SSD-83870463 | 15A-15B Moseley Street and 25-31 Donald Street, Carlingford | Review of Response to Submissions

The purpose of this letter and the supporting documentation is to provide a response to the request for additional information (**RFI**) letter provided by Department of Planning, Housing and Infrastructure (**DPHI**) on 22 January 2026. Amended and/or updated documentation has been included with this response as follows.

**2** PROPOSED CONTEXTURAL MASSING STUDY - OPTION 1  
1 : 500

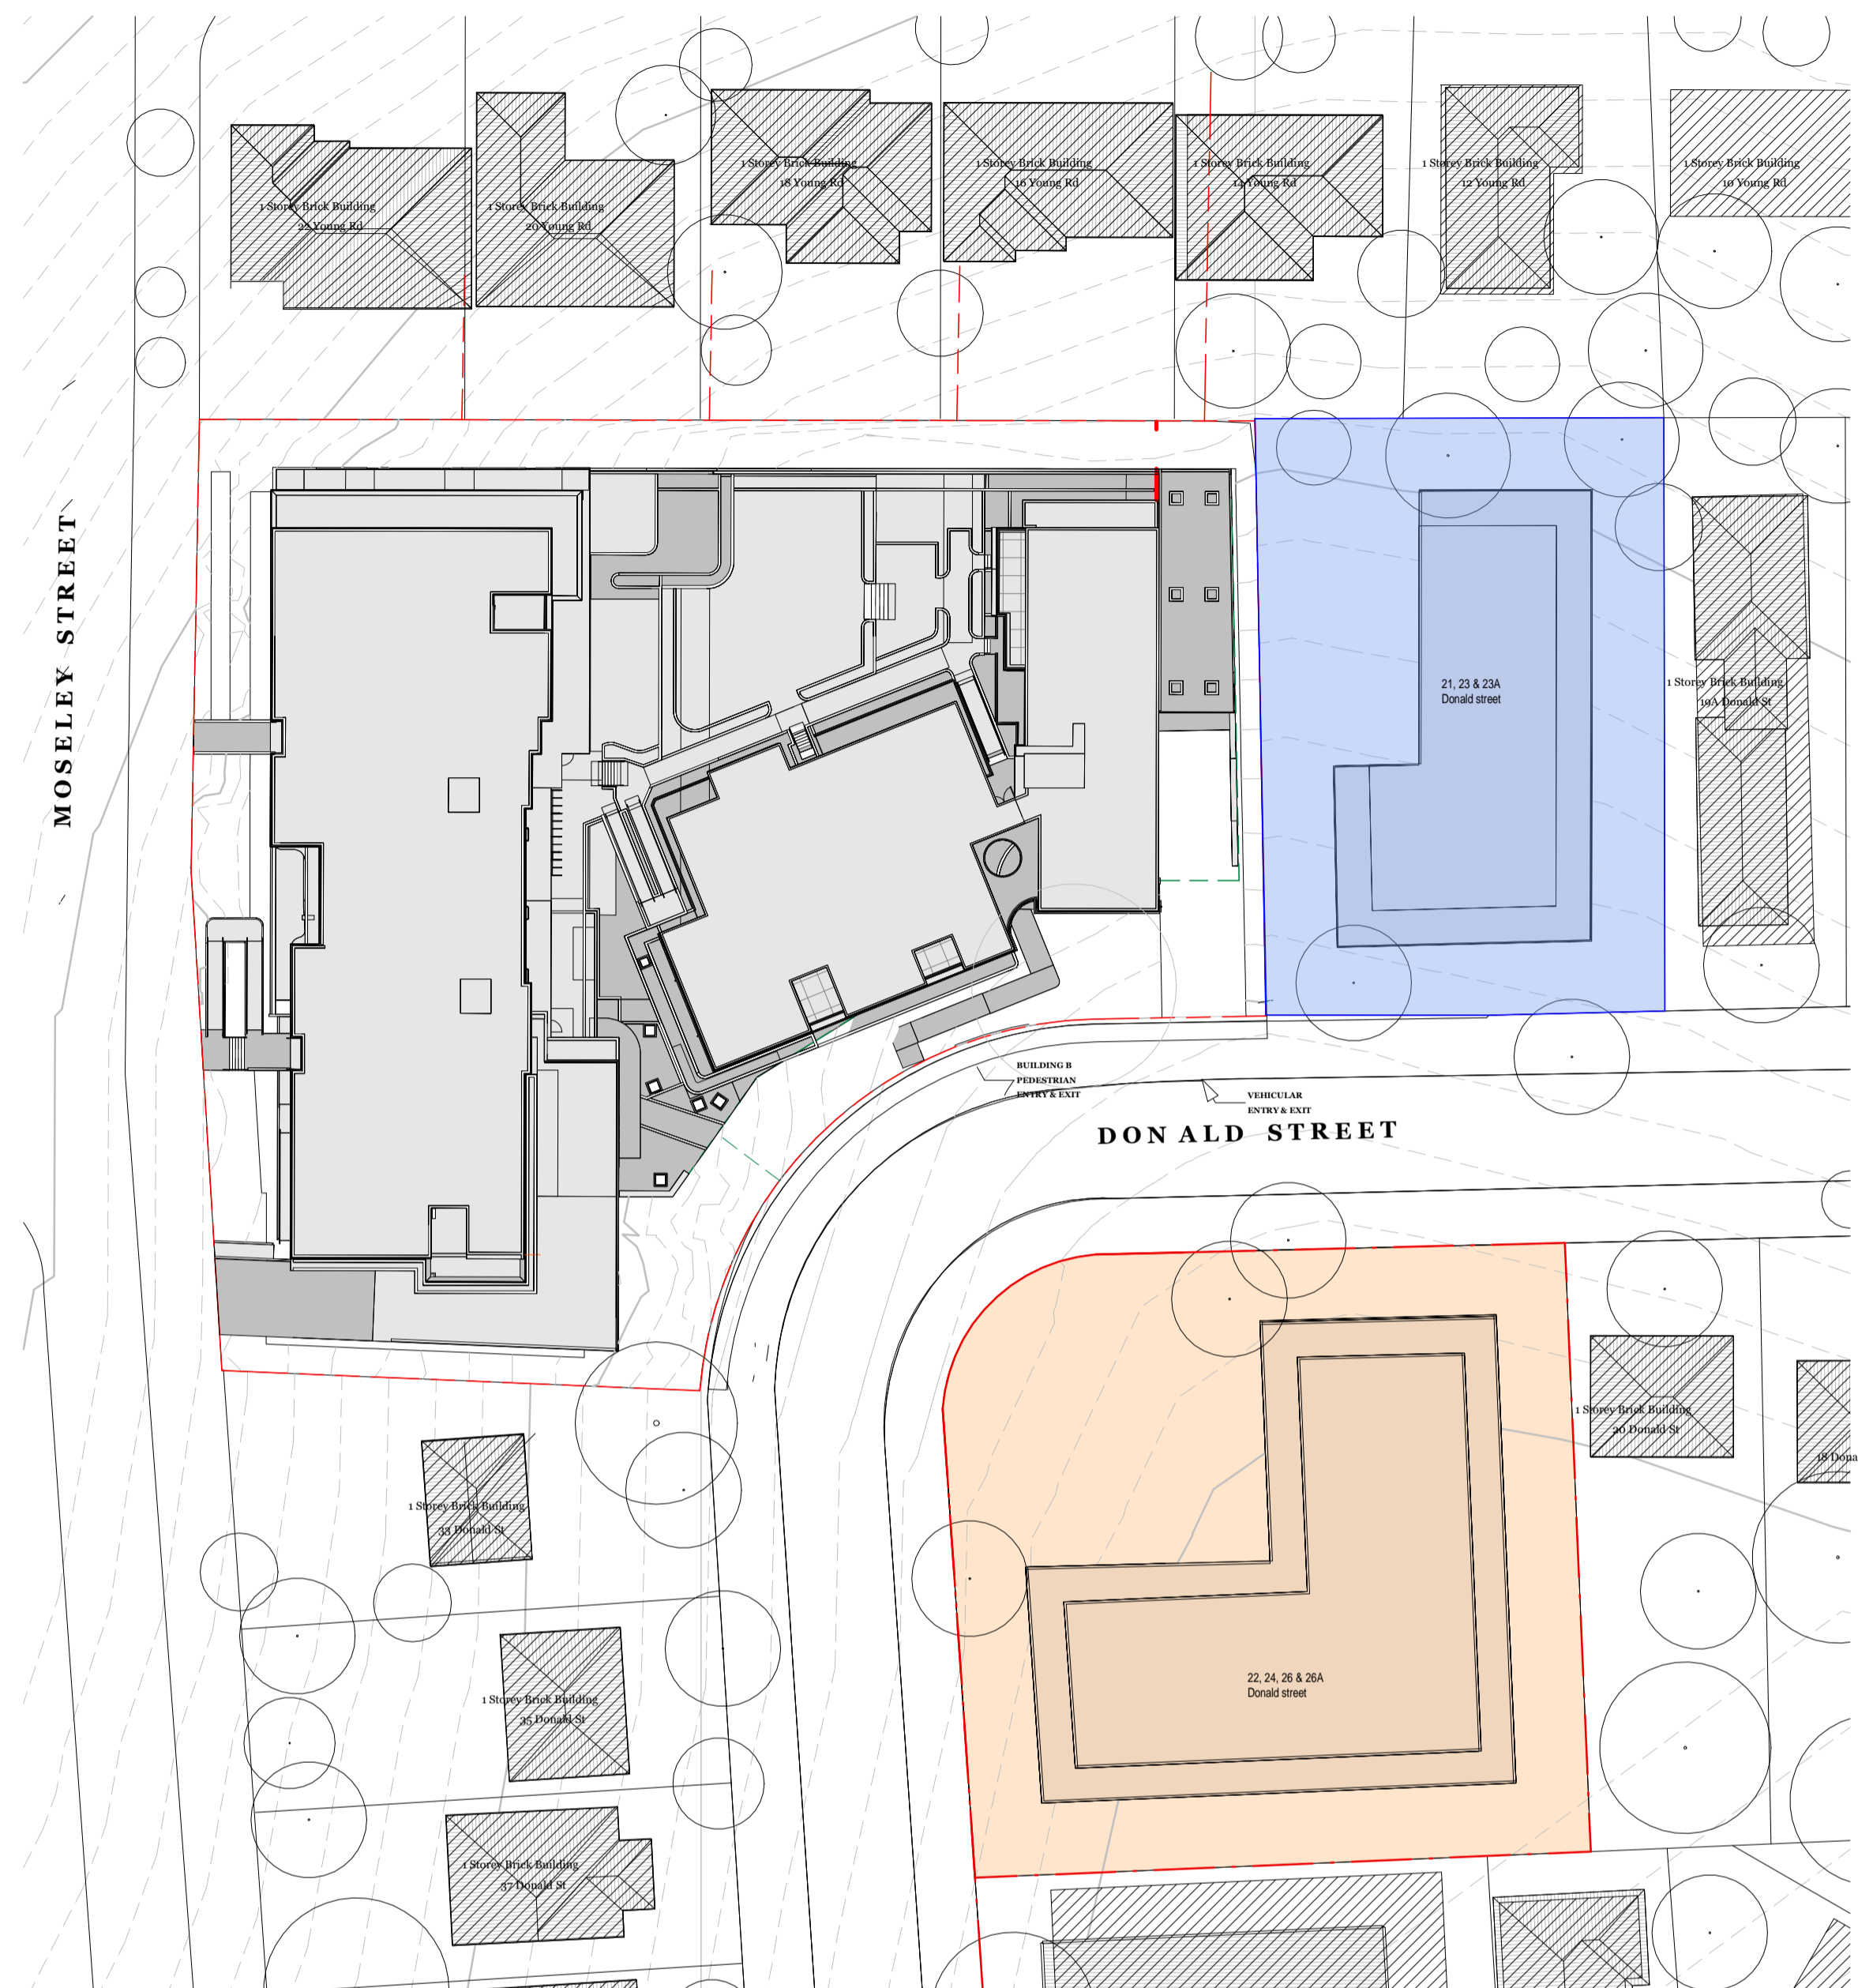
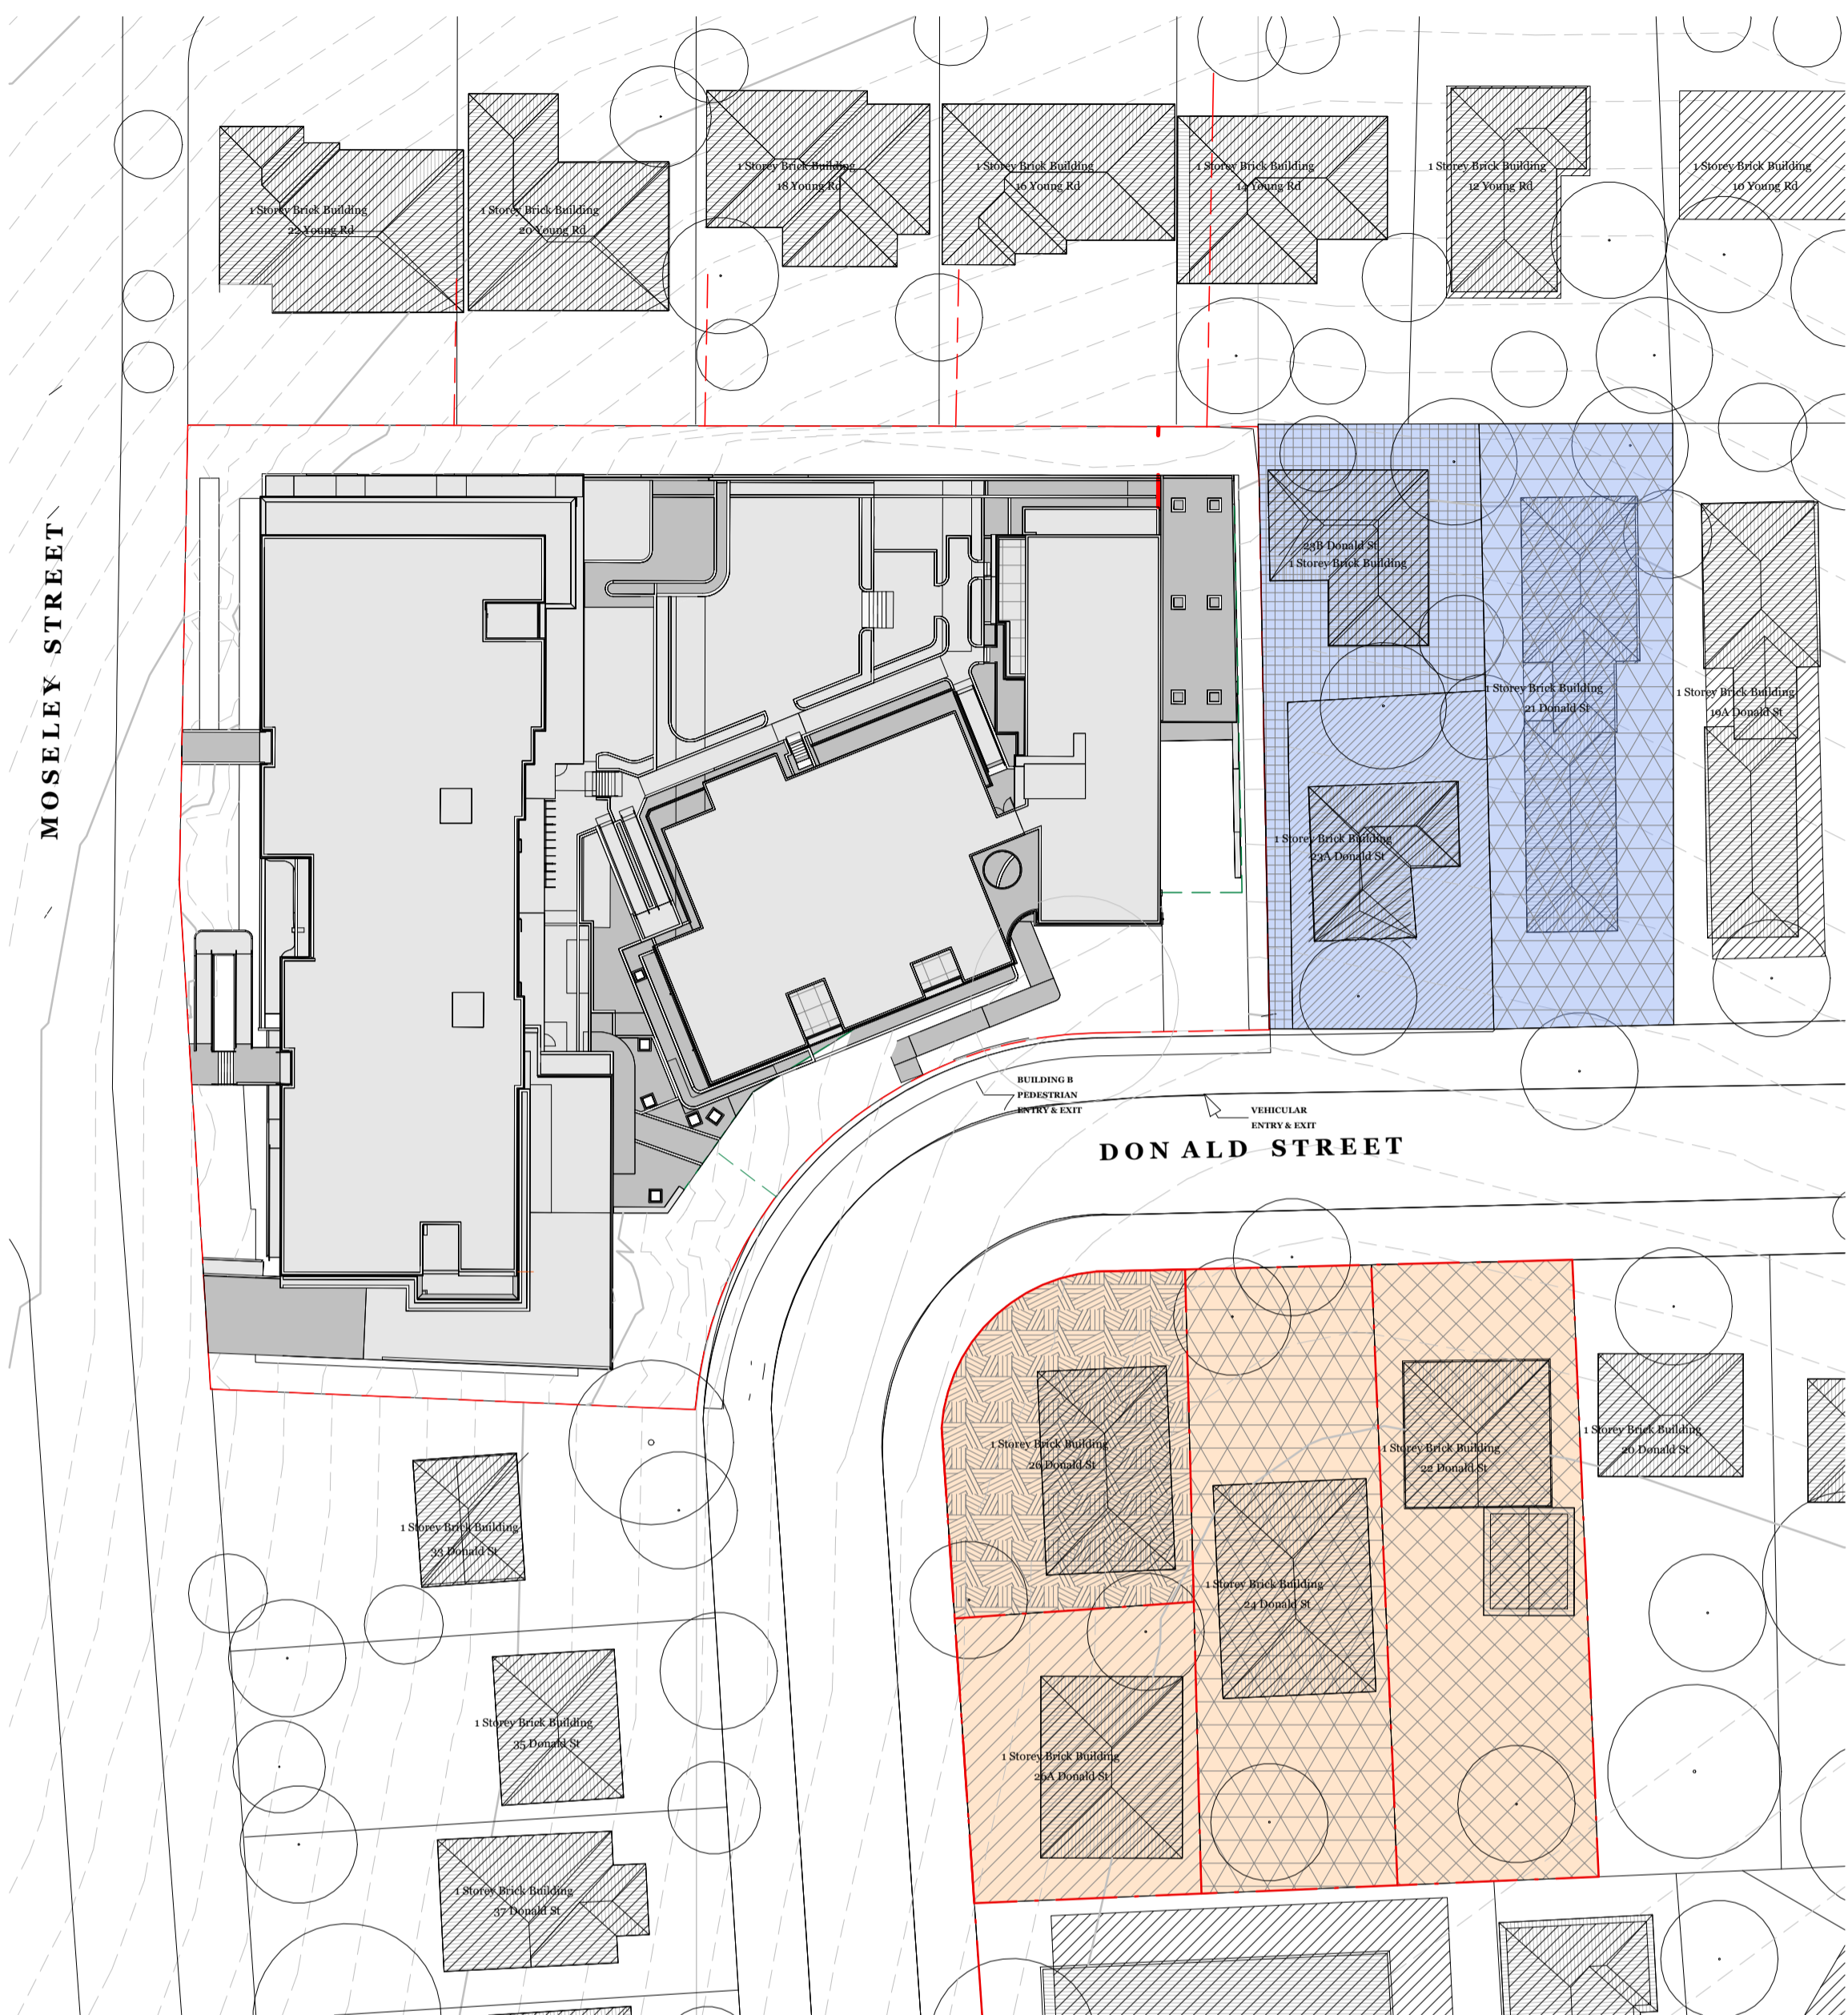
Issue	DPHI Comment	Project Response
Low and Mid-Rise (LMR) Provisions	<ul style="list-style-type: none"> ▪ <i>As previously advised (on 20/11/2025 and 23/12/2025), the amended design, which does not comply with the Height of Building or FSR standards, directly impacts the neighbouring properties to the south-west on Donald Street. It is critical that the amendment report specifically addresses these impacts, particularly through a more detailed solar access analysis for the affected properties.</i> ▪ <i>The analysis provided to date is insufficient to allow a robust assessment of the proposal. Please therefore revise the amendment report package to address the following:</i> <ul style="list-style-type: none"> – <i>The sun eye diagrams must clearly show the massing of all adjoining properties that are being impacted (overshadowed) by the development</i> – <i>The solar access analysis must include consideration of how the overshadowed properties on Donald Street would be affected if they are developed under the LMR.</i> 	<p>The amendment report has been updated to provide a more thorough assessment of solar impacts to properties on Donald Street to the south (see Section 5.1.3).</p> <p>Additional sun eye diagrams have been prepared which provide a consideration of how the overshadowed properties on Donald Street would be affected if they are developed under the LMR. This has been done by preparing two hypothetical development scenarios under the LMR controls and including these into the existing sun eye diagrams. While the impact at 9am on both hypothetical scenarios is noted, it quickly reduces at 10am and 11am respectively. By 12pm, the sun eye diagrams clearly show there is no impact from overshadowing created by the project on these sites.</p> <p>Refer page 50–56 of the Architectural Design Report.</p>
